June 22, 2016

Re: Bogan Brothers Painting
3435 Vassar Dr., NE
Traffic Circulation Layout
Engineer's/Architect's Stamp **6-6-16** (G16-D150)

Based upon the information provided in your submittal received 6-21-16, the above referenced plan cannot be approved for Building Permit until the following comments are addressed:

**TCL**

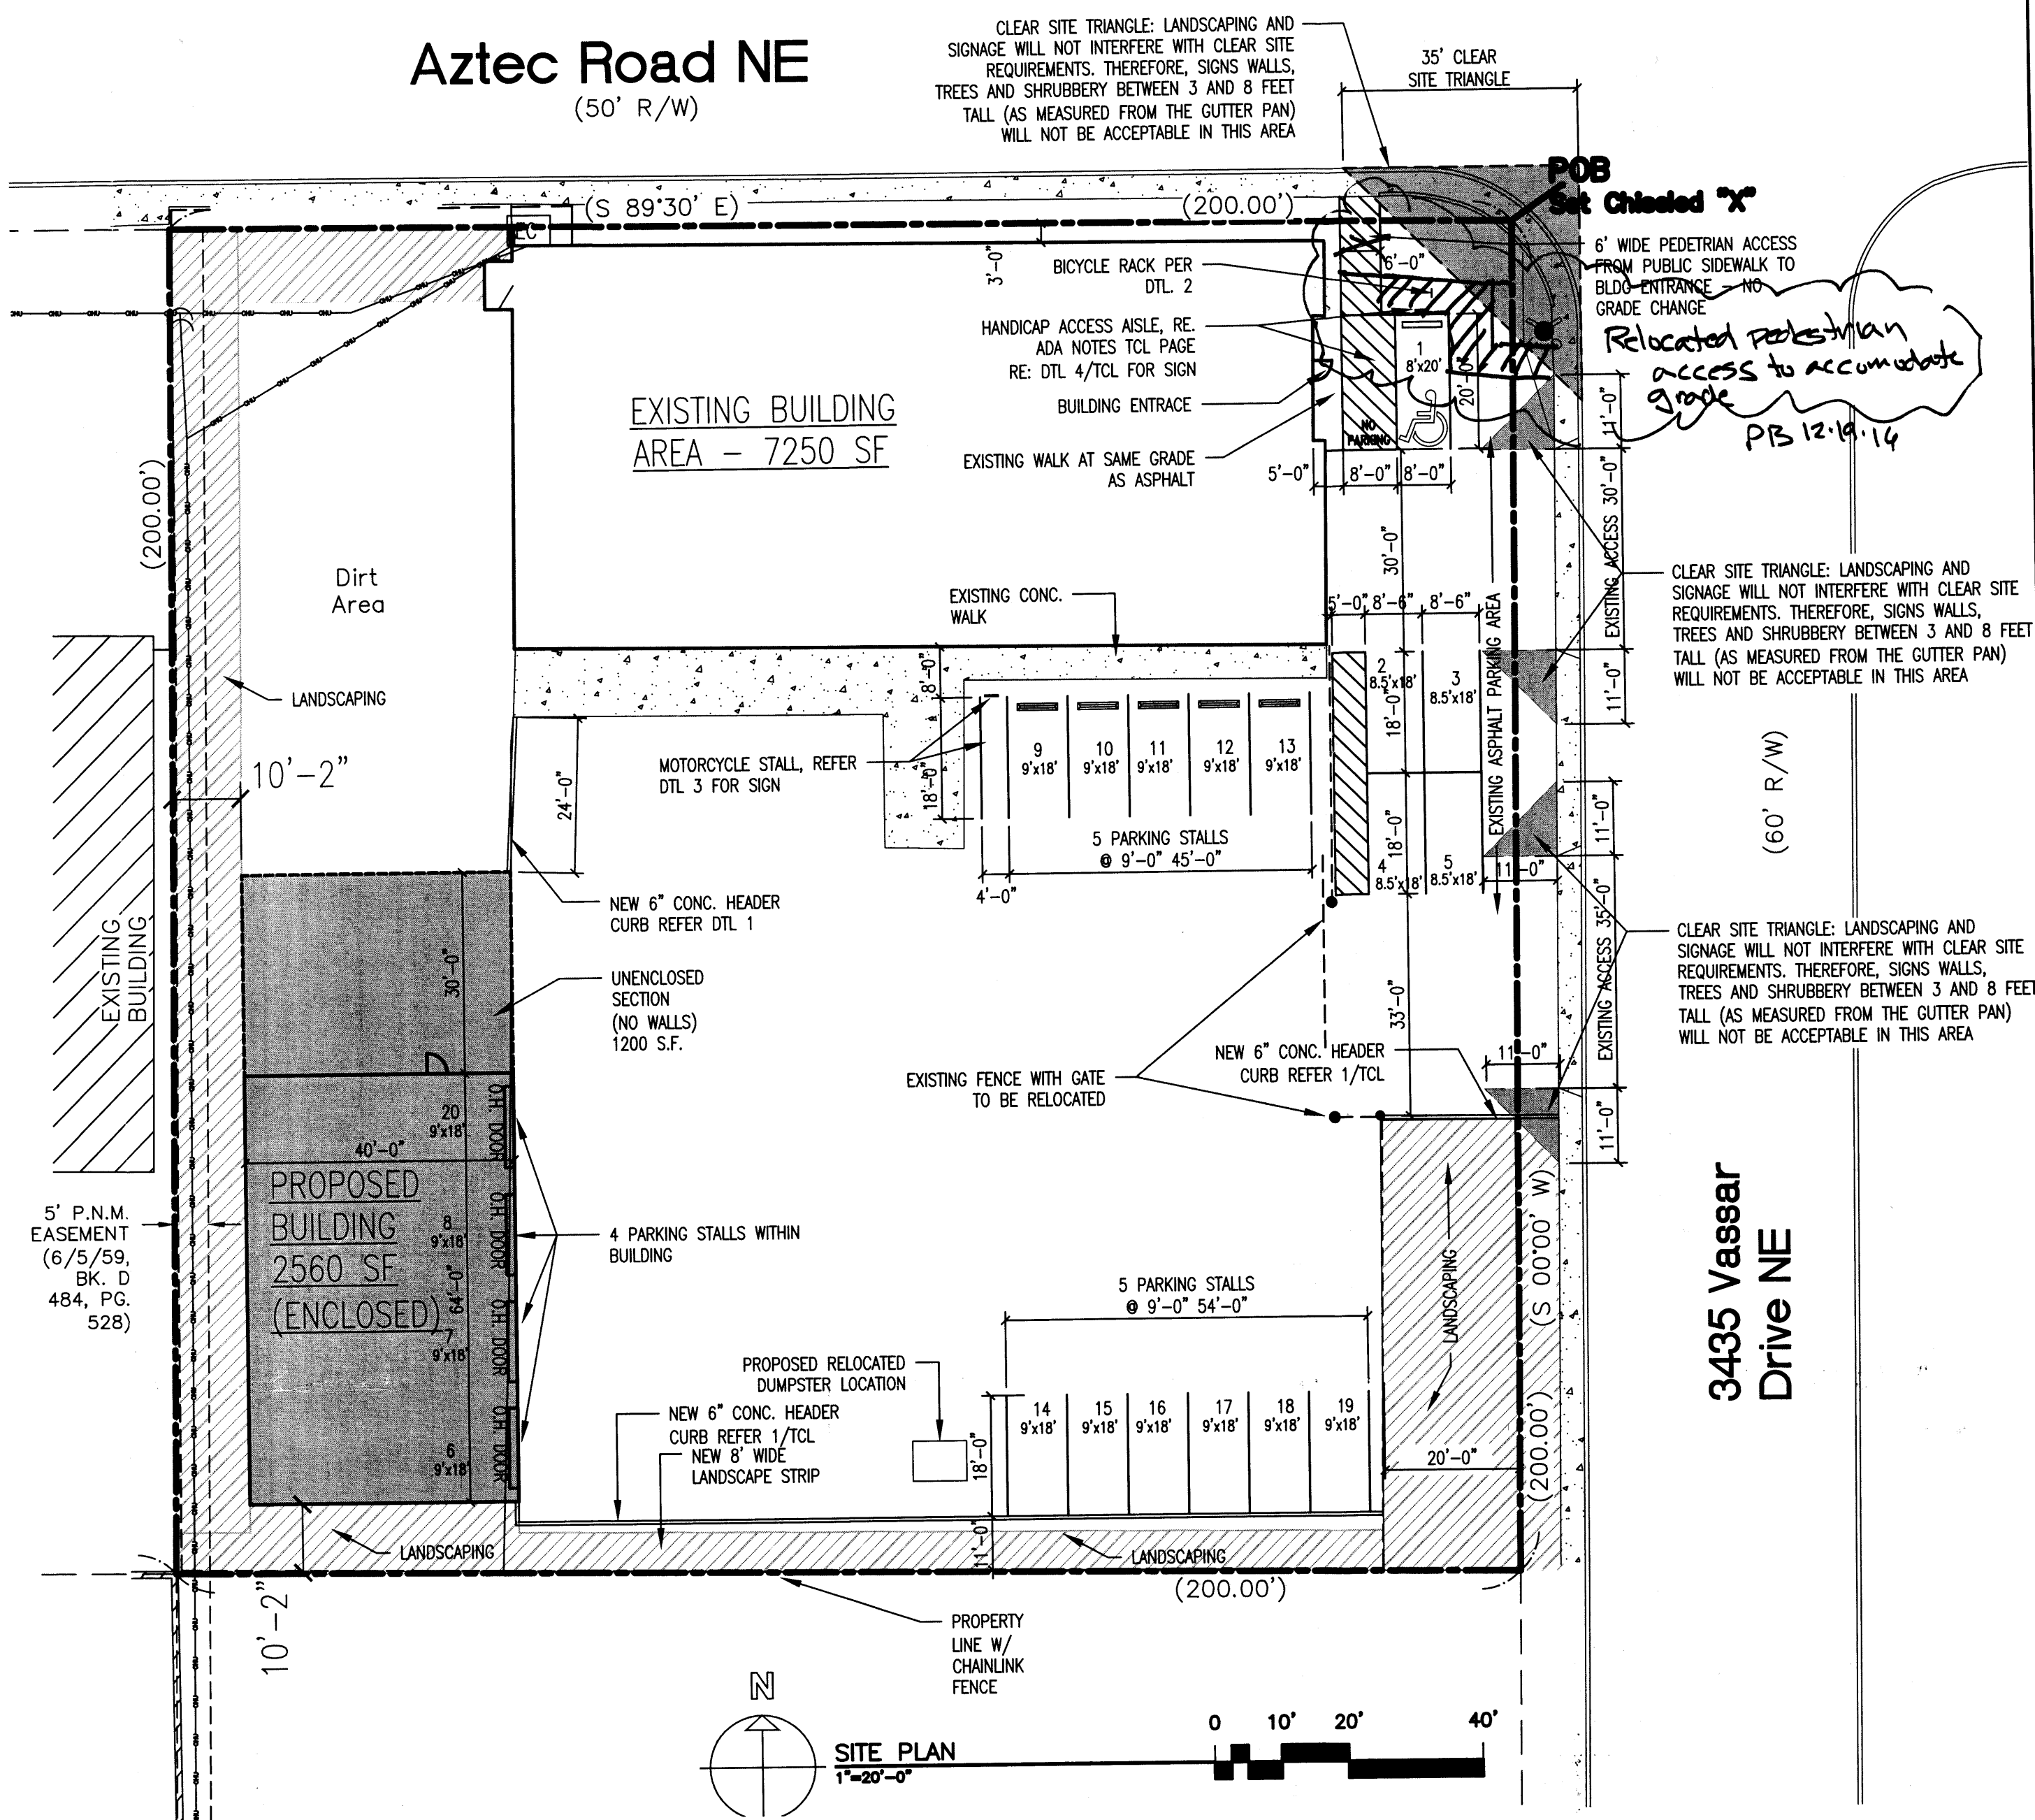
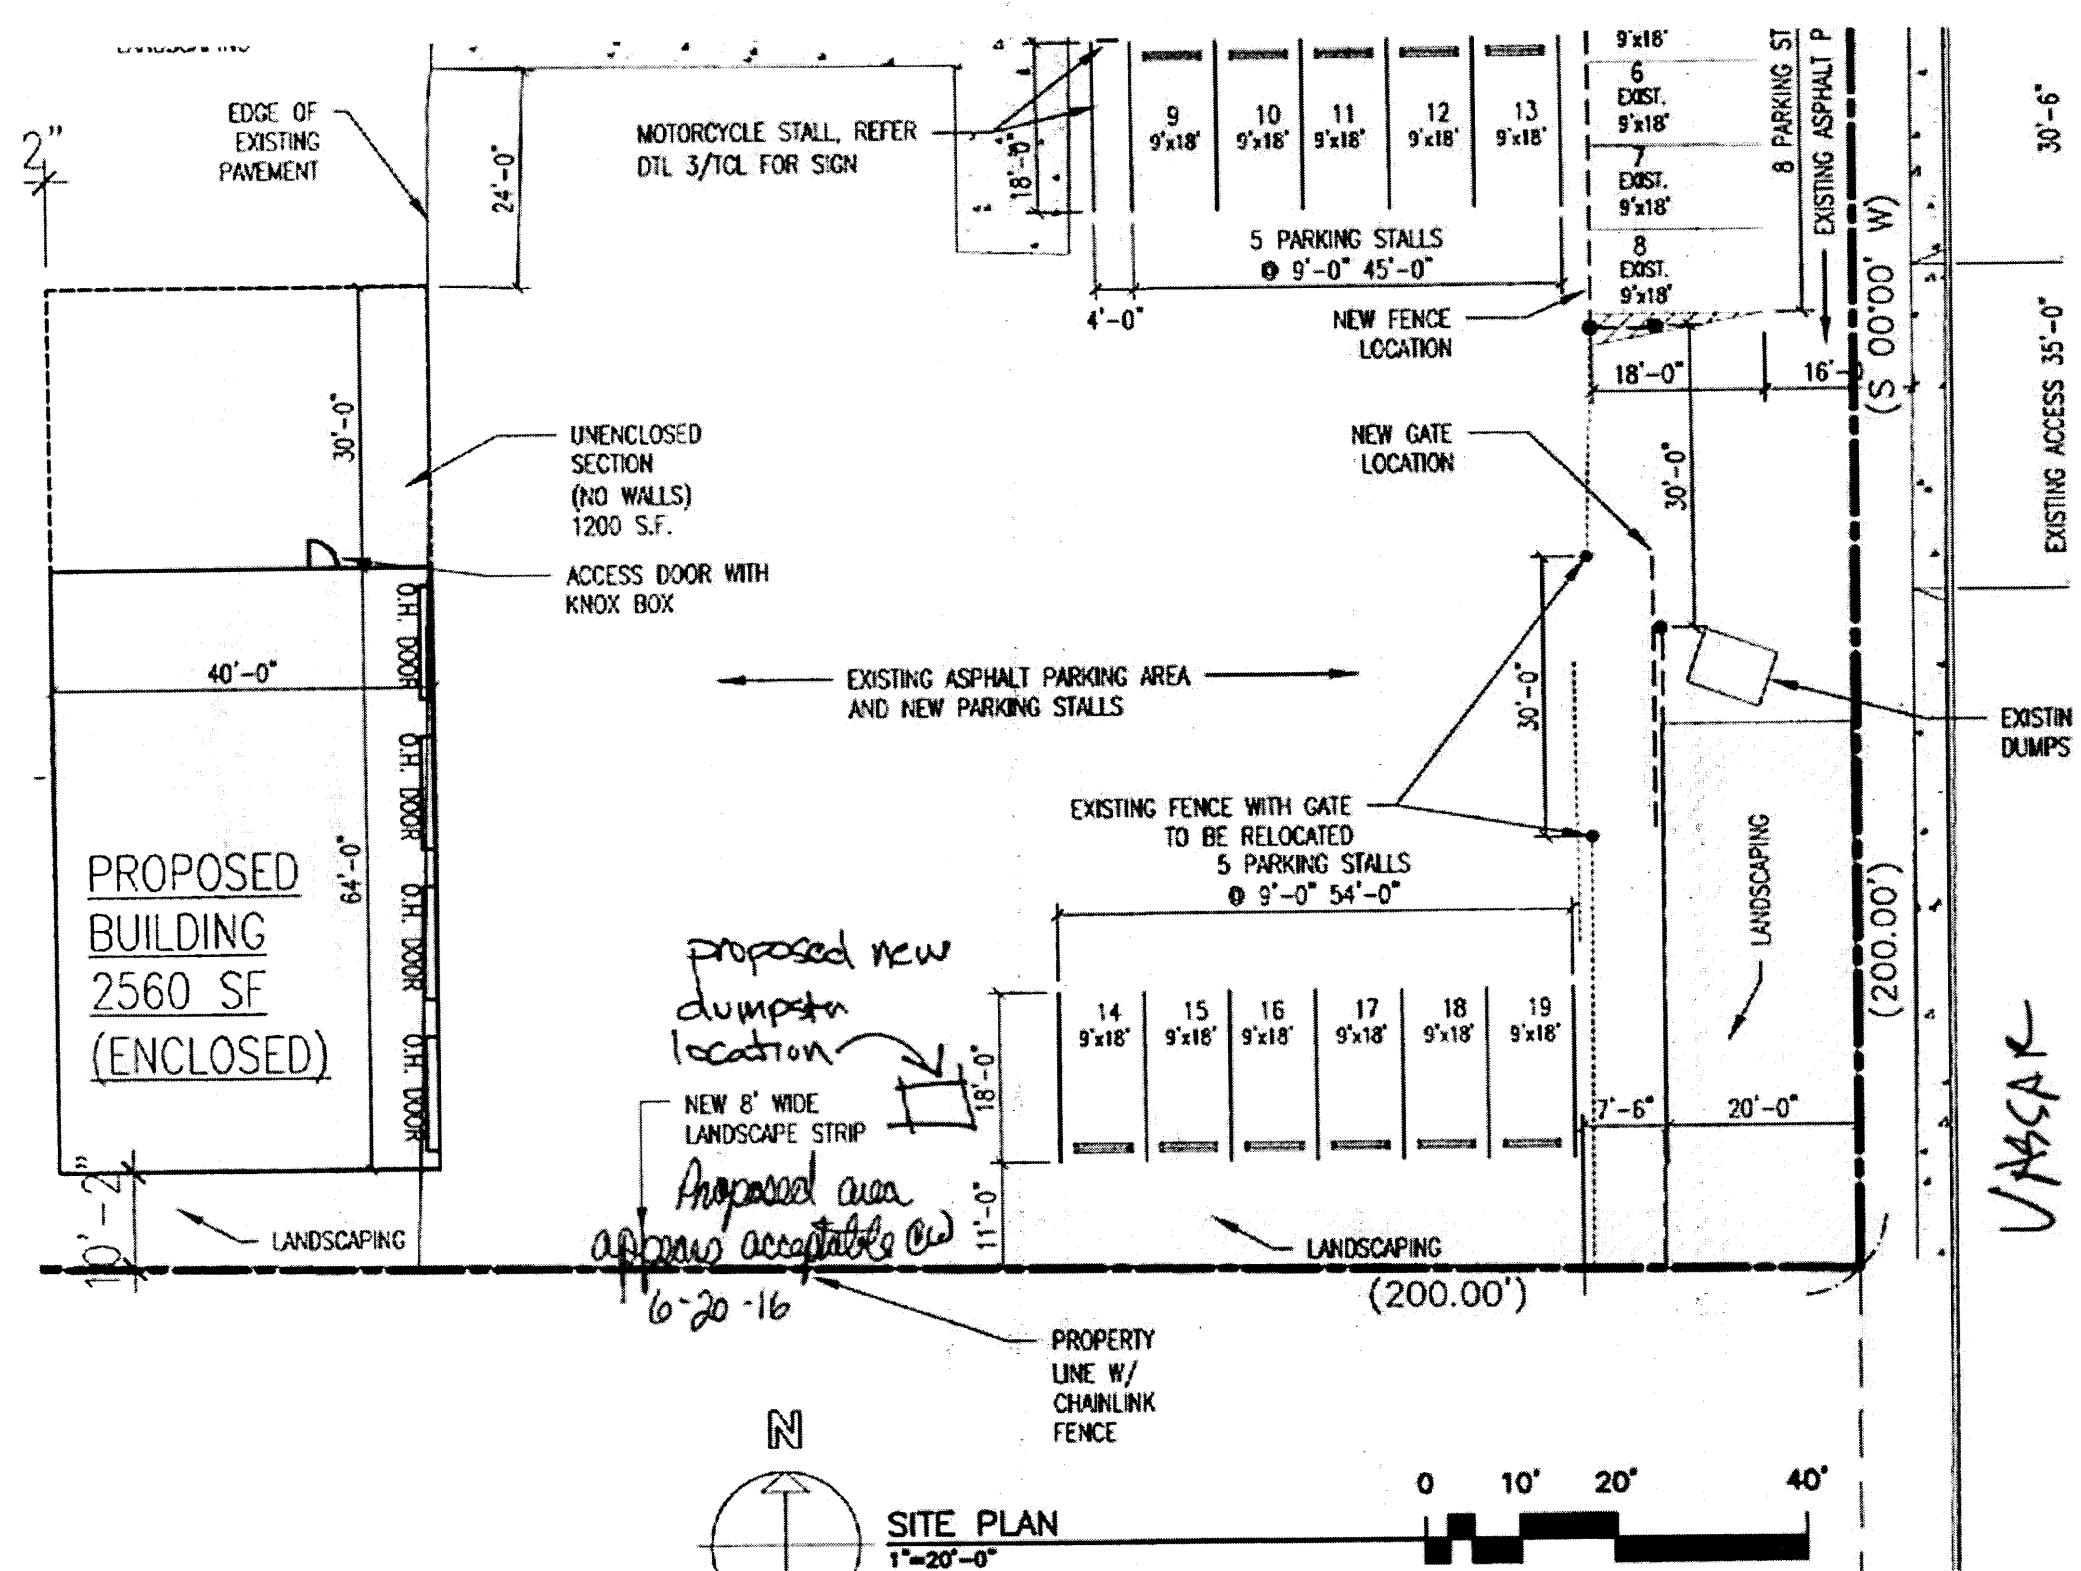
1. Please detail and dimension all buildings, parking spaces and ADA ramps and anything that influences the parking and circulation on the site. Previous digital maps show parking spaces on the north east corner of the parcel. Please detail the existing ADA ramps on the existing curb cuts.

2. Parking spaces are required to be a minimum of 8.5 ft. by 20 ft. In review of the submitted plans, the parking spaces on the east side of the existing building are not adequate in length and do not provide a minimum of 24 ft. drive pad between the parking spaces and the ROW for adequate backing up of vehicles. It is preferable that vehicles do not back up onto streets when exiting.

3. Per DPM, a 6 ft. wide ADA accessible pedestrian pathway is required from the HC parking stall access aisles to the building entrances. Please clearly show this pathway and provide details. Please dimension the access isle.

4. ADA parking spaces require a minimum of 8.5 ft. X 20 ft. per parking space. Please revise site plan to accommodate adequate ADA parking spaces and access isle. In review of the submitted site plan, the parking spaces are 16 ft. in length. Evaluate moving HC spaces to south east corner of the existing building and providing a 6 ft. pedestrian access to the building entrance. The parking spaces may also be angled, if appropriate for the design.

5. Service vehicle and/or refuse vehicle maneuvering must be contained on-site; provide a copy of refuse approval.
6. All broken or cracked sidewalk and ADA ramps must be replaced with sidewalk and curb & gutter. A build note must be provided referring to the appropriate City Standard drawing.
